## 1.0 Landscape

This response is made with primary reference to document AP-044 3.1.32 Environmental Statement Chapter 30 Landscape and Visual Impact Assessment, and documents AP-083 to AP-088, 3.2.26 Environmental Statement Chapter 30, Figures Part 1 to 6.

The key elements of North Falls project include the proposed Offshore Wind Farm, the Onshore Substation (OnSS), onshore Export Cable Corridor (onshore ECC) and the landfall (where the offshore export cables will meet the onshore export cables).

Proposed Norwich to Tilbury OHL	
---------------------------------	---

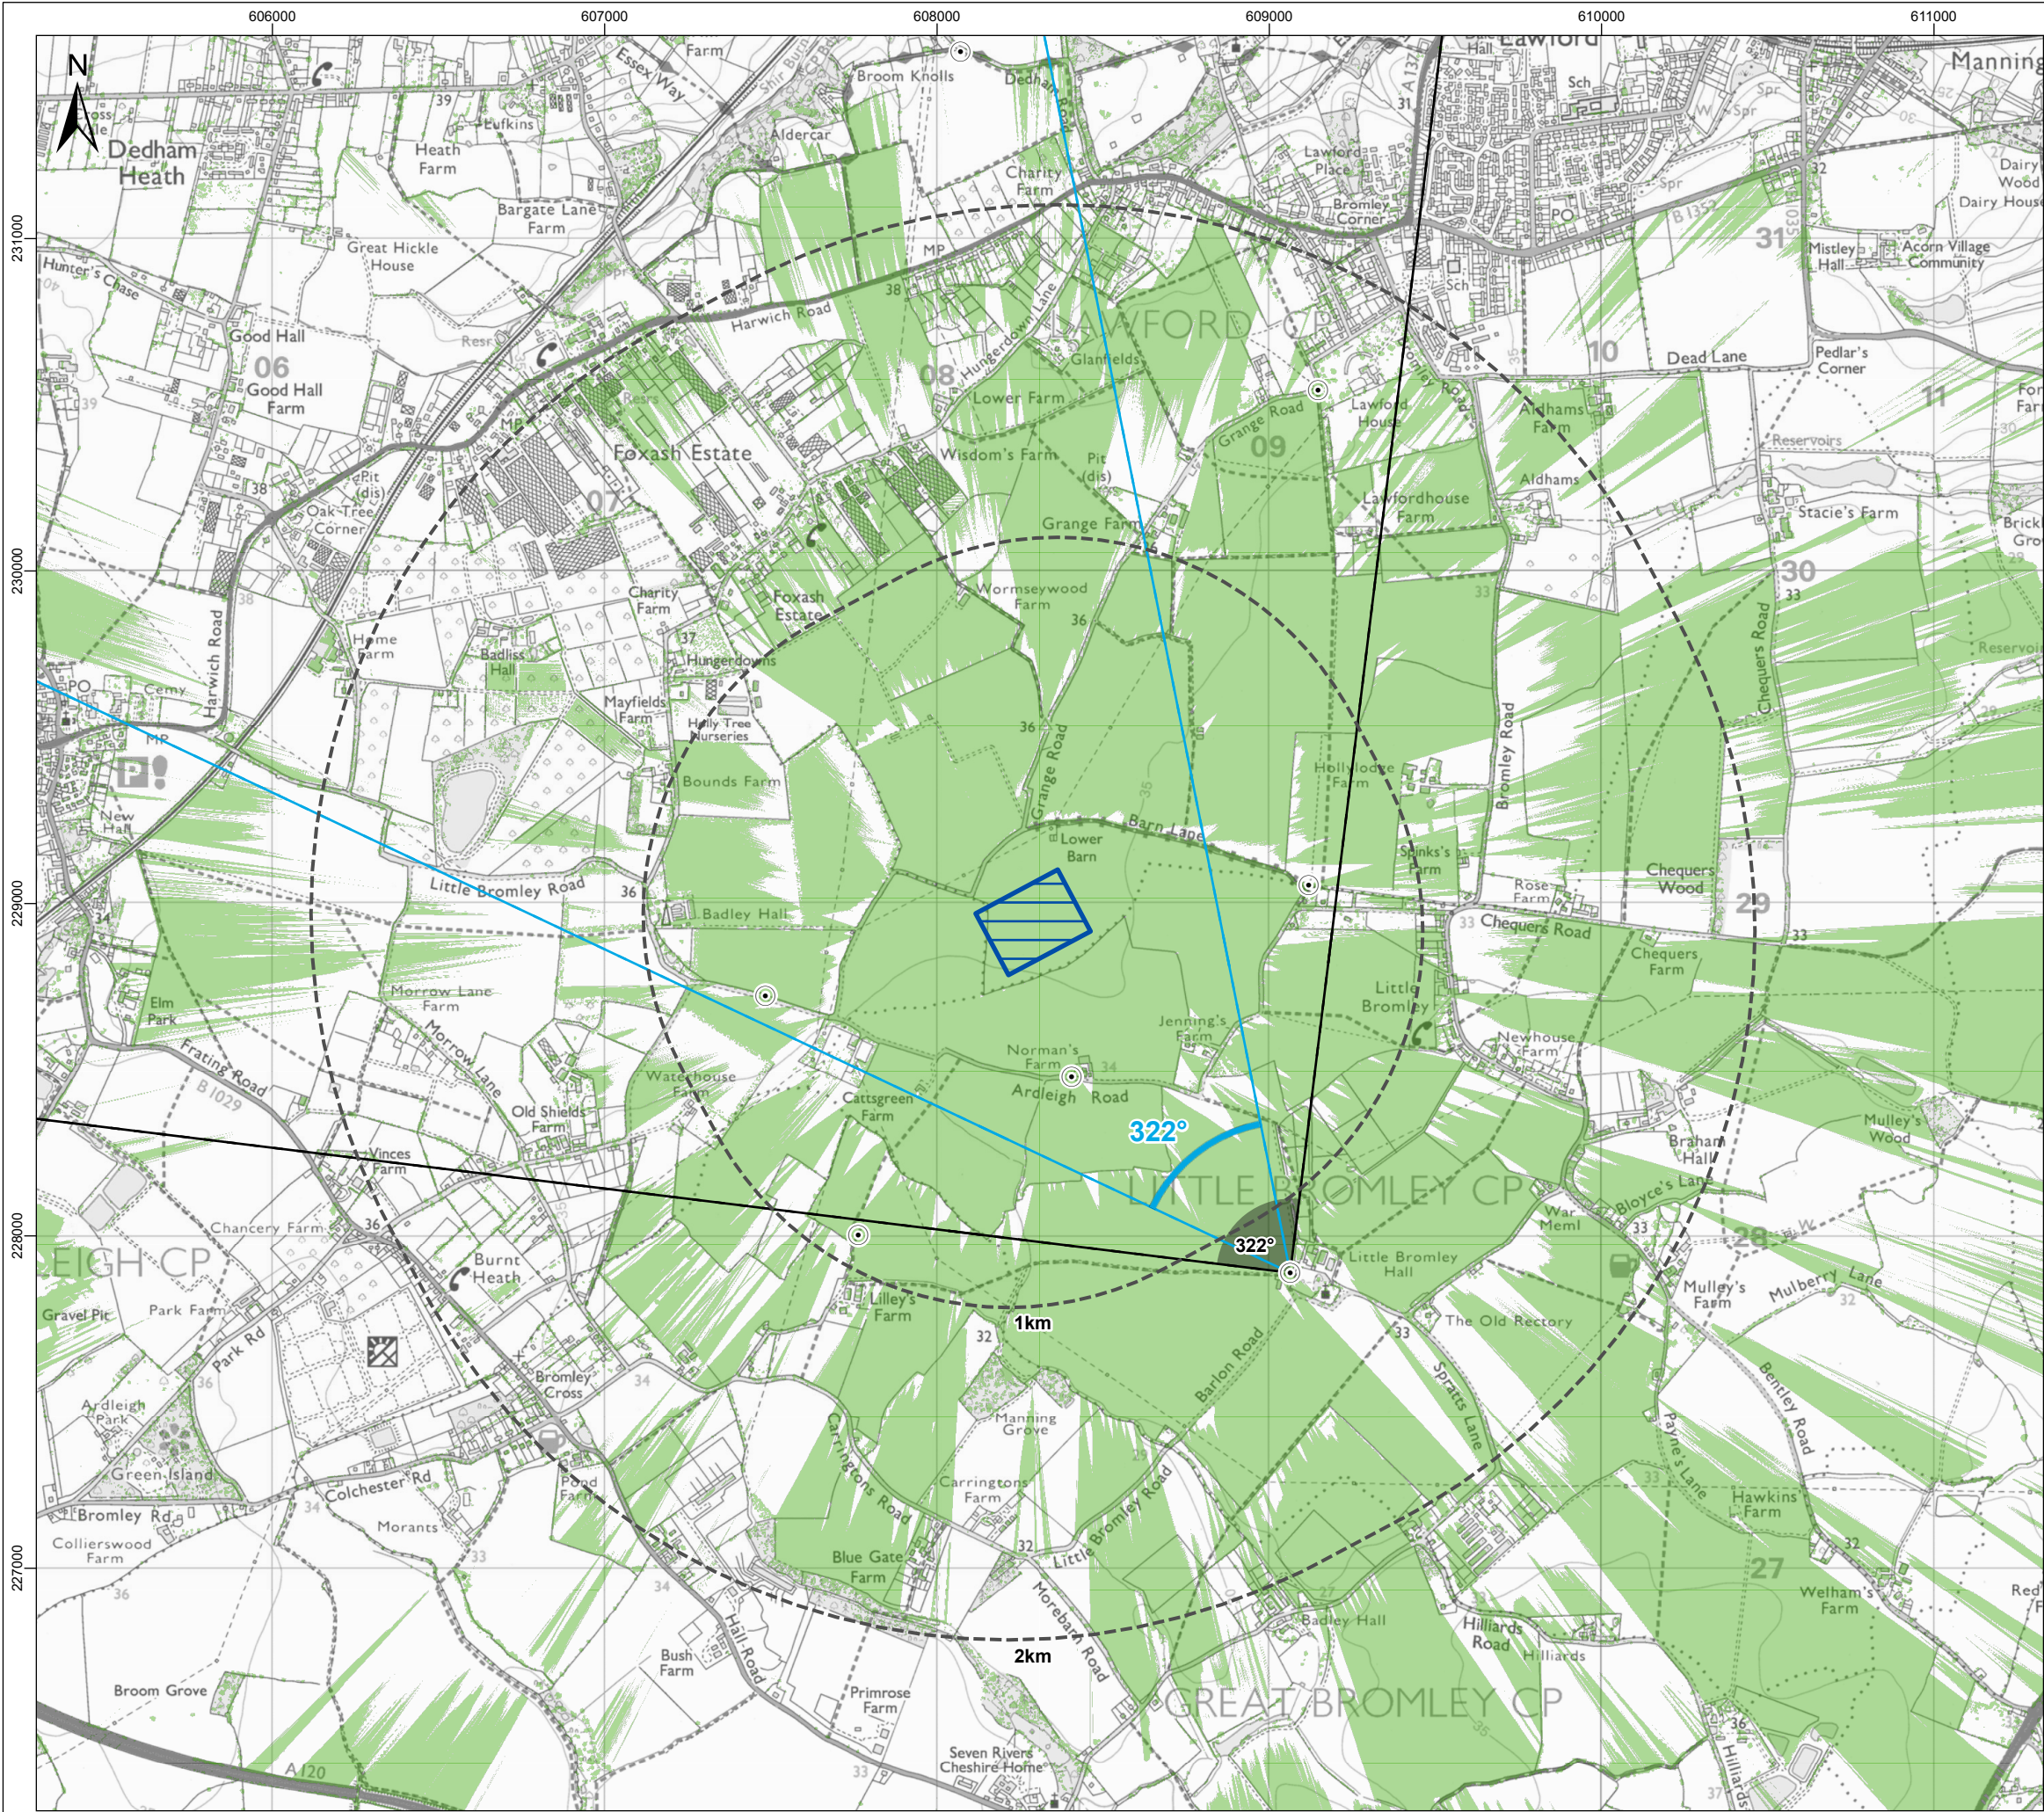
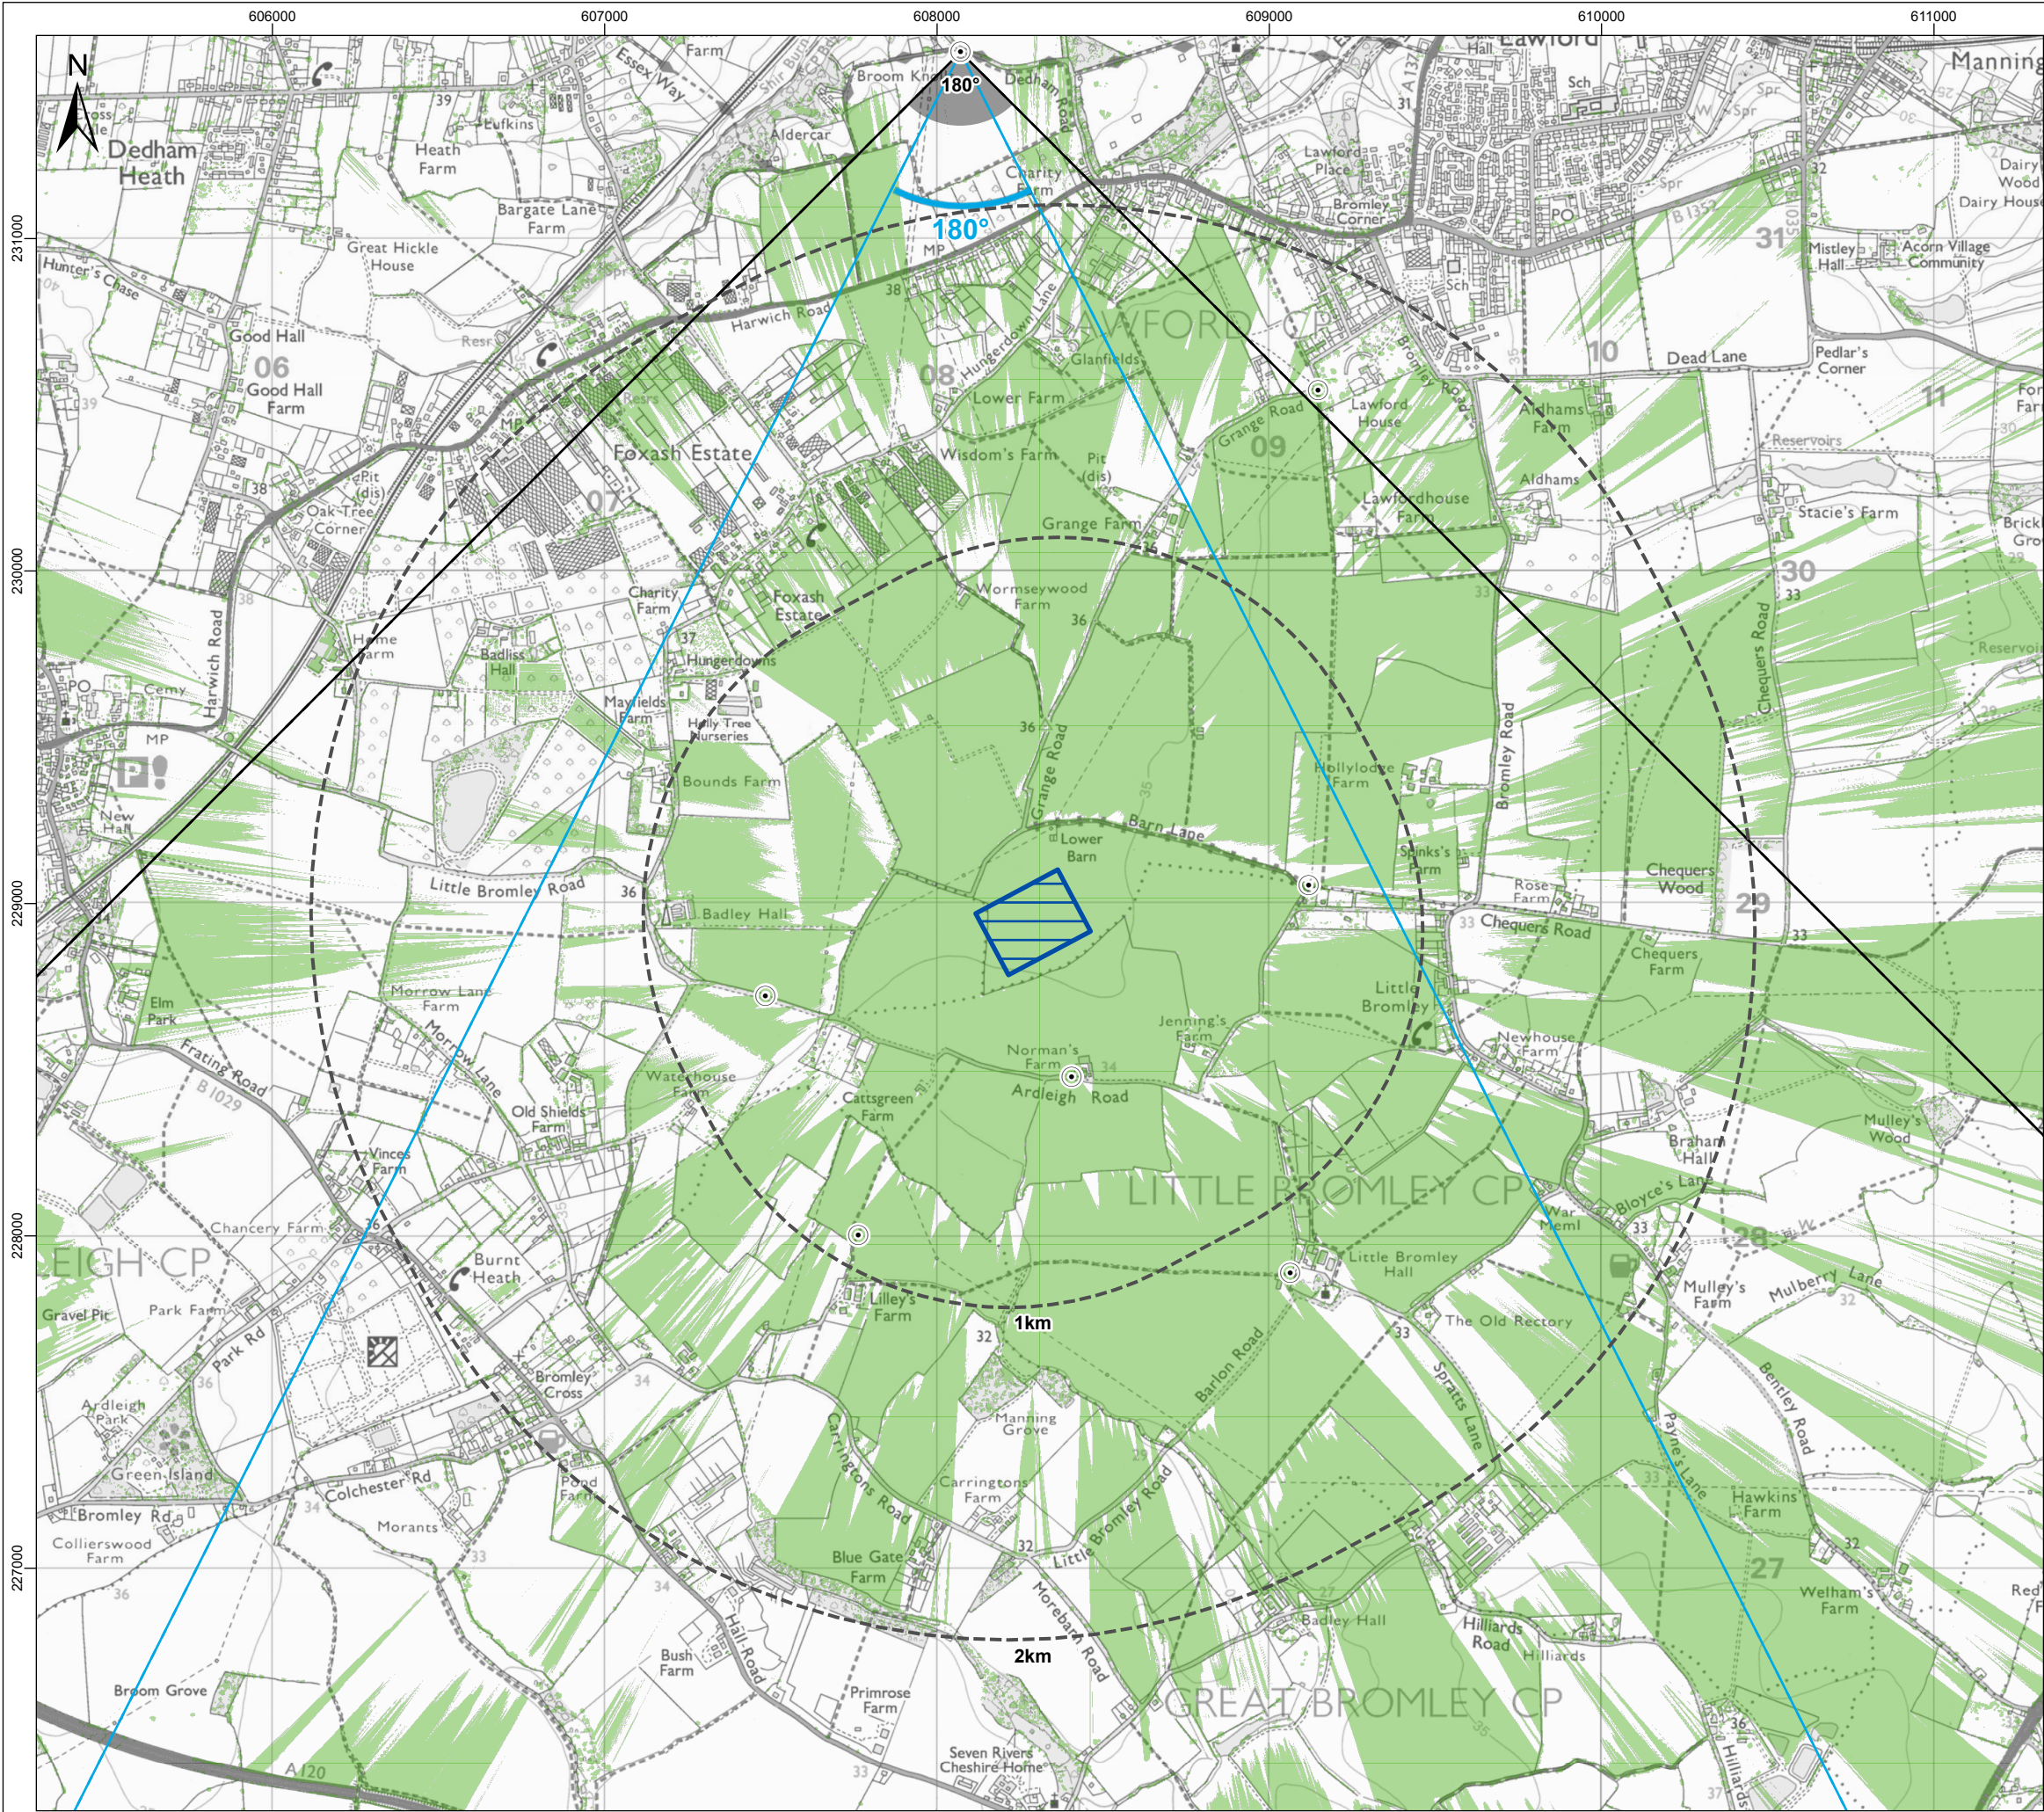
The N2T pylons do not appear to be identified in the cumulative LVIA visualisations, and therefore it is assumed they haven't formed part of the LVIA cumulative impact assessment itself. The pylons form will form part of the DCO for the Norwich to Tilbury project, along with the EACN so their cumulative impact needs to be considered.

GLVIA3 (Landscape Institute and Institute of Environmental Management and Assessment, 2013) defines cumulative landscape and visual effects as those that '*result from additional changes to the landscape and visual amenity caused by the proposed development in conjunction with other developments (associated with or separate to it), or actions that occurred in the past, present or are likely to occur in the foreseeable future.*' However, it is clear that the overhead element of the Norwich to Tilbury proposals have not been included in the visualisations provided with the assessment so we assume have not been assessed. The overhead pylons need to be included in the visualisations and the cumulative impacts re-assessed.
